From:
Sent: 13 September 2023 14:18
To: DCAdmin
Subject: Comments to Emley development Newett Homes

Comments in relation to the following applications by Newett Homes;

2023/92255 Land at Green Acres Close, Emley, Variation of Conditions 1 (Plans) , 2 (Crime Prevention) and 15 (Permitted Development) of Previous reserved matters approval 2021/93286 pursuant to outline permission 2020/91215 And

2023/92327 Land at Green Acres Close – modified plans for 6 Dwellings plus parking and landscaping and modified plans for ball stop netting.

Construction Management Plan (drawing reference NLM-005-A)

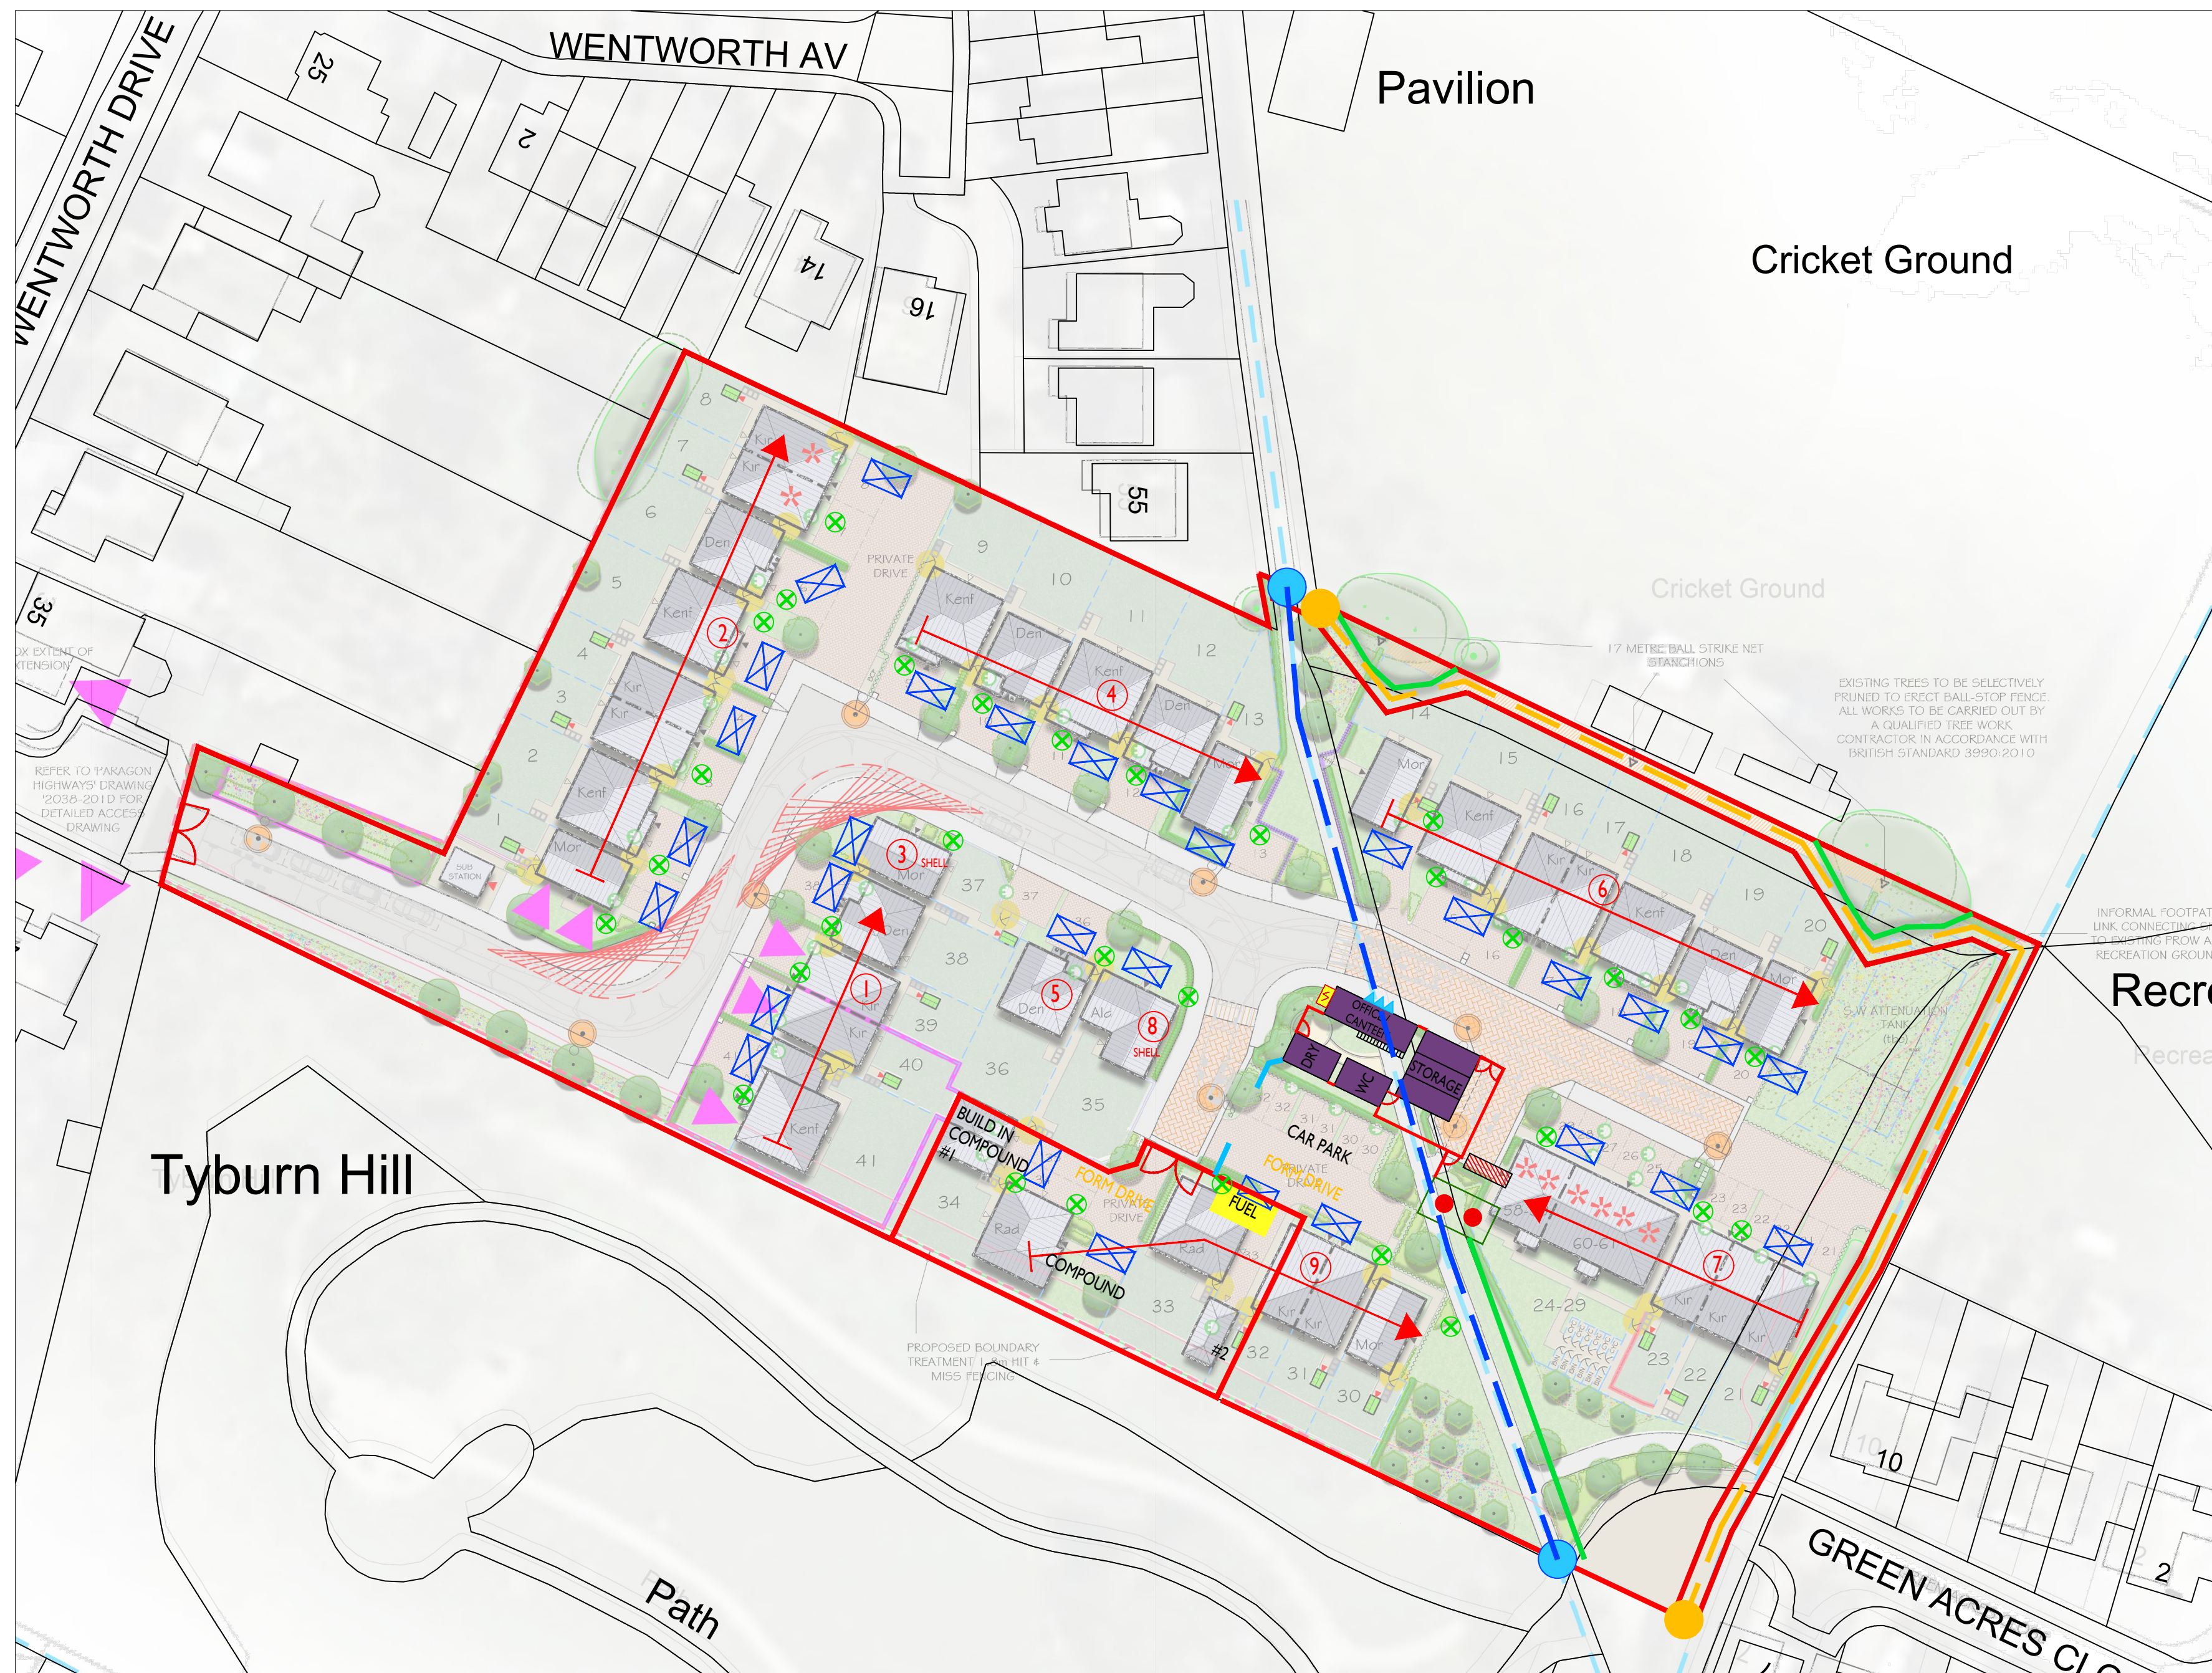
15 – It was disappointing to note that Newett Homes initially brought in contractors through the Green Acres Close entrance despite it being clear in the Planning Consent that access through Green Acres could only be used by Emergency Service or the Millennium Green.

6 – Parking of construction workers vehicles will be an issue, what are the plans?

7 – Reassurance that the access from Green Acres Close will not be used by construction workers or deliveries.
